Rezoning Transportation Analysis

Petition Number: 2019-174

From: Felix Obregon, PE
fobregon@charlottenc.gov
704-432-5729

Date	Description
01-14-2020	First Review-MTH
02-17-2020	Second Review

RZ-1

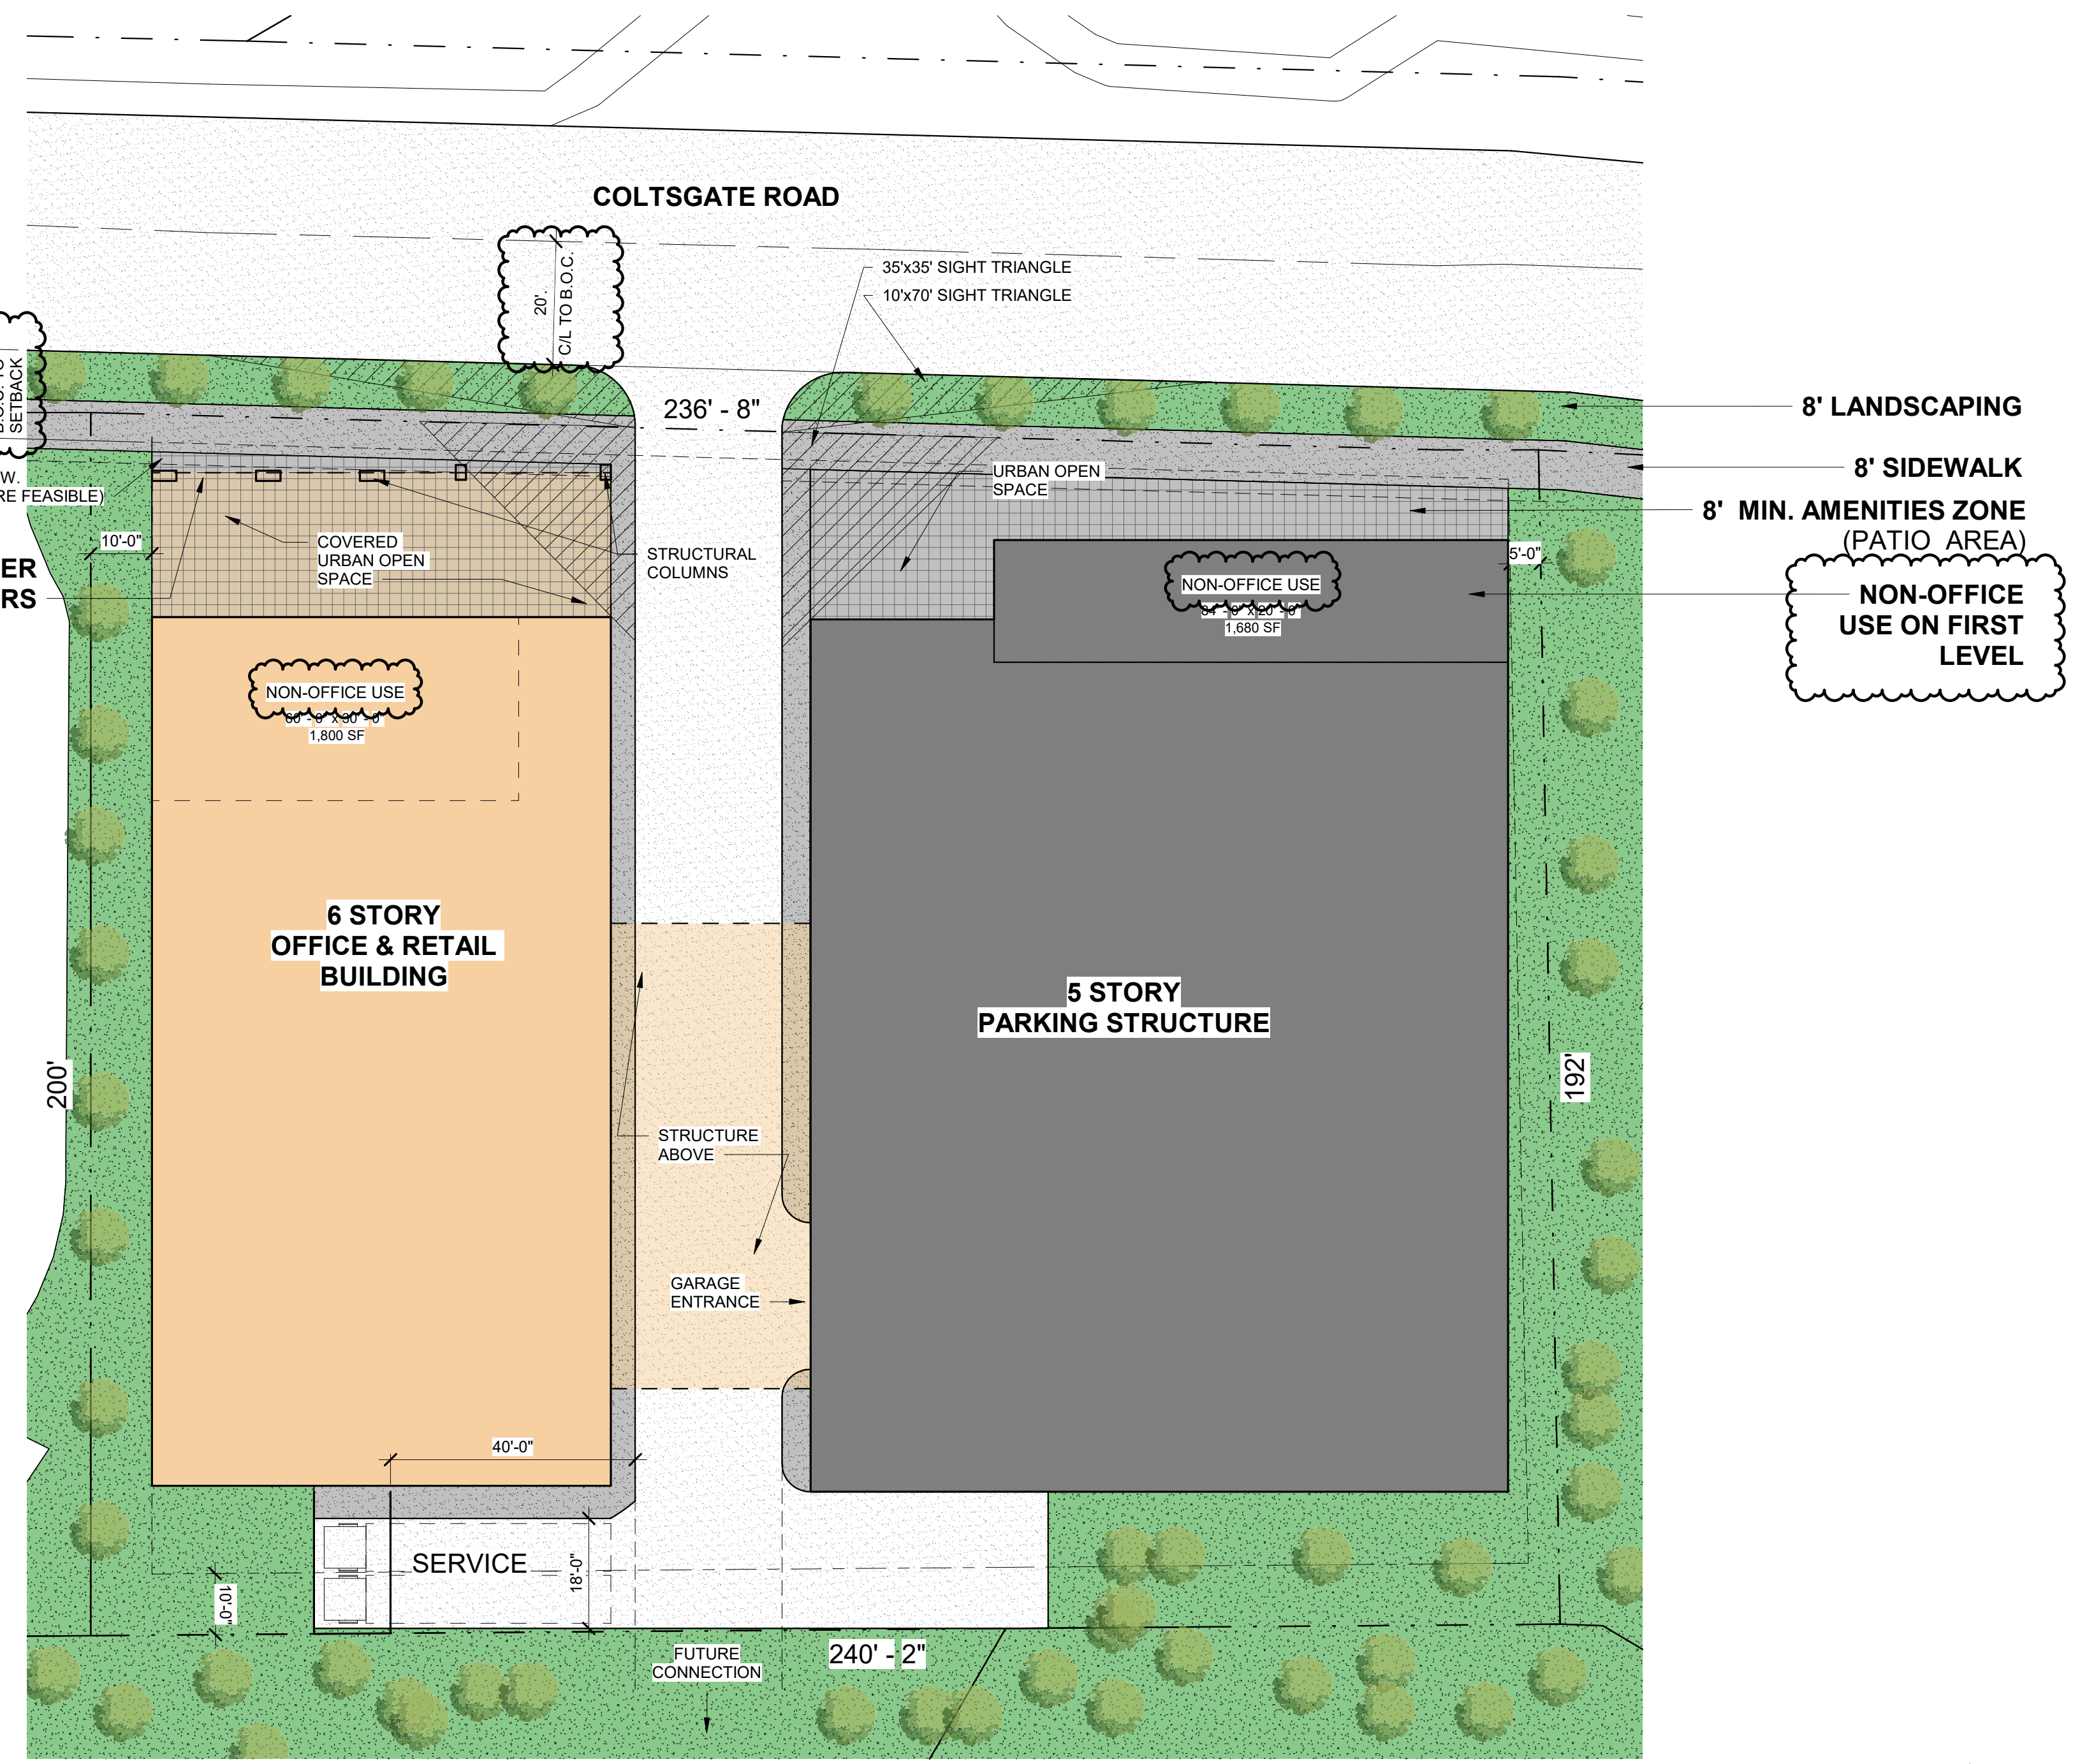
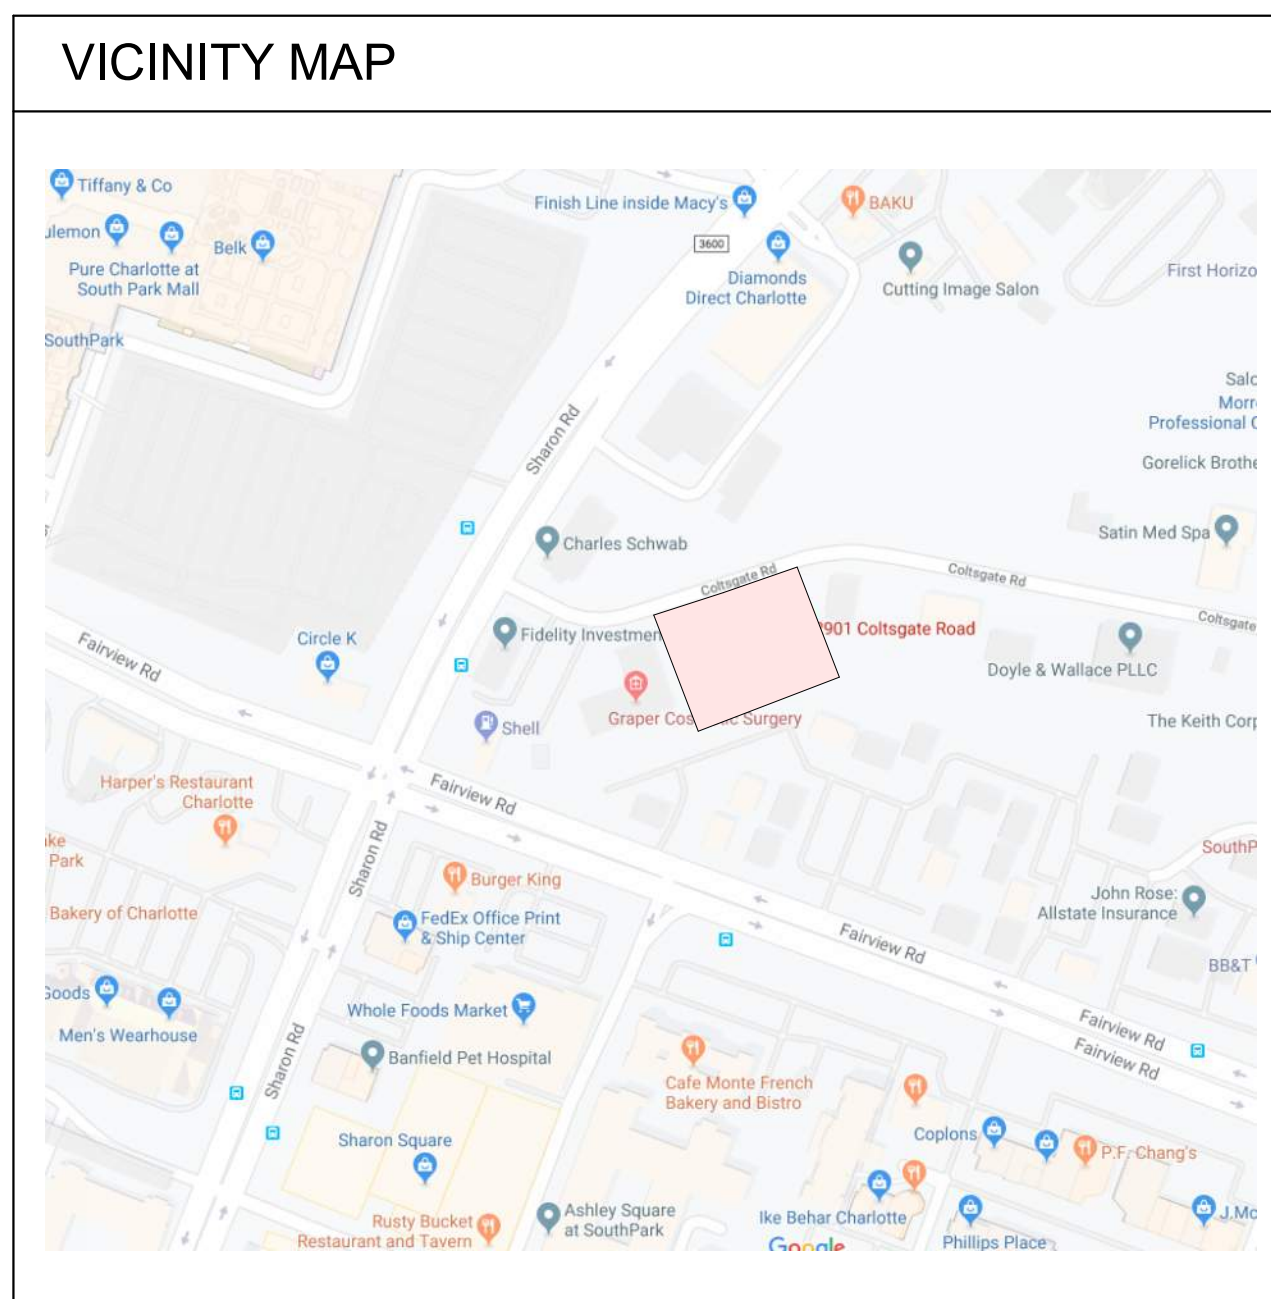
The site is located on a local road in the SouthPark area near a high congested intersection of Sharon Road and Fairview Road. The petitioner is proposing an 8-foot planting strip and 8-foot sidewalk along Coltsgate Road. The petitioner should revise the site plan to meet the ordinance required setback and clearly label the location of the setback.

1. **Curbline** The proposed zoning district has a setback measured from back of the existing or proposed future curbline.
 - a. **Colsgate Road:** The future location of curb and gutter is in its existing location.

The site plan should show the curb and gutter labeled and dimensioned from the centerline for each road.

Technical Correction based on site plan 02/10/2020: Petitioner is showing dimension from C/L to what appears to be edge of pavement, please updated to dimension existing back of curb.
